Your reference : MP10_0007 and MP10_0008
Our reference : DOC10/53302
Contact : Liz Peterson 9995 6841

Re: Hoxton Park Industrial Estate Basin 6 Modification Application (10_0007 MOD 2 and 10_0008 MOD 2)

GISELLE HOWARD
Director, Metropolitan Branch
Environment Protection and Regulation

**Figure 15** – Location of threatened Biota and Habitat Resources

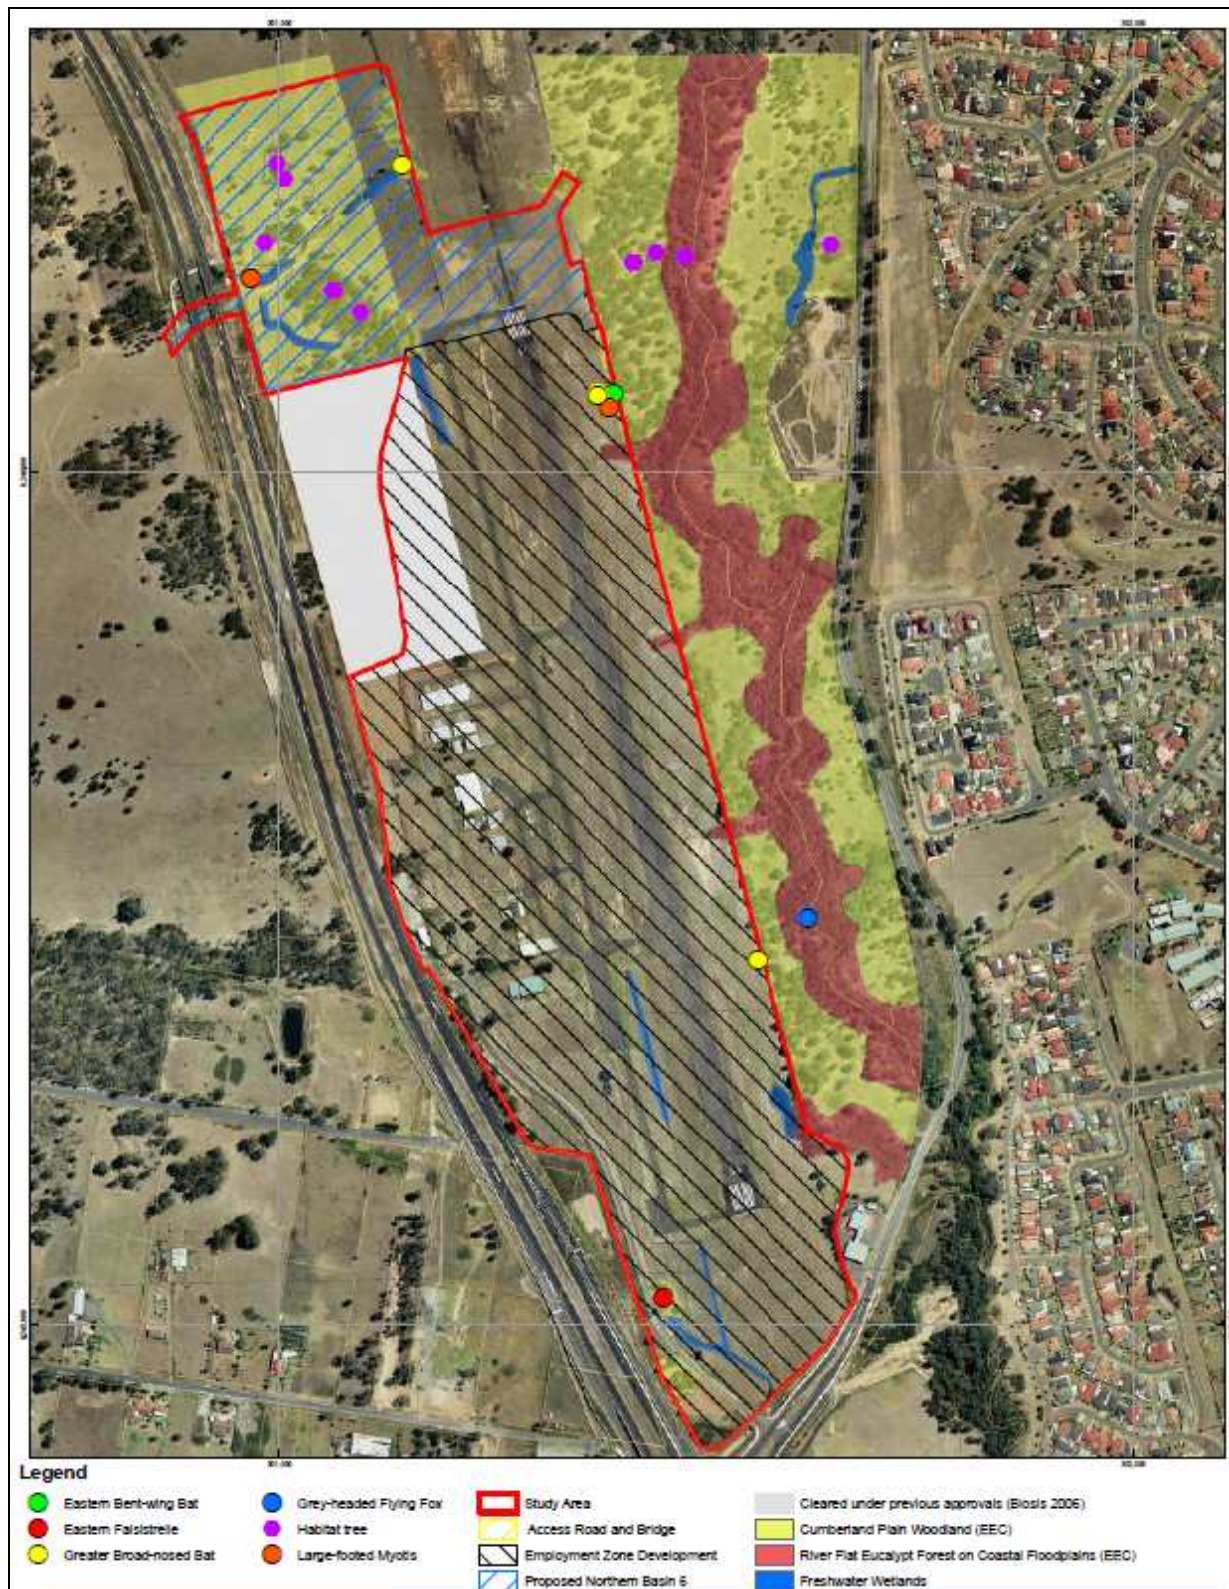
DECCW notes that the construction of the proposed infrastructure would require the clearing or permanent modification of native vegetation within the development footprint for the northern basin and the spillway. The impacts on vegetation summarised in Table 7 on page 46 of the Ecological Impact Assessment Report prepared by GHD (October 2010) indicates that there will be 5.19 Ha of Cumberland Plain Woodland lost.

**Figure 17** – Aboriginal Management Plan

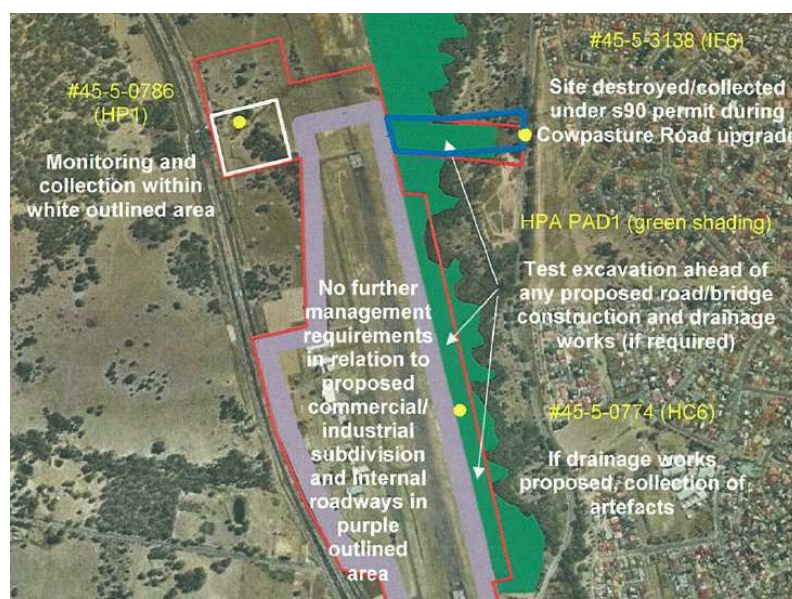
DECCW recommends that the Department of Planning seek clarification about the extent of works associated with the existing tailouts within the Hinchinbrook Creek corridor. If the existing tailouts are to be widened or deepened as part of the Detention Basin works, it is recommended that subsurface testing be undertaken in order this area is required in order to assess the archaeological significance of the identified potential archaeological deposit (HPA PAD1).

DECCW recommends that any proposed subsurface archaeological investigation program be conducted in accordance with the DECCW *Code of Practice for Archaeological Investigation of Aboriginal Objects in New South Wales*. If the testing program determines that HPA PAD1 is archaeologically significant, salvage excavation may be appropriate.
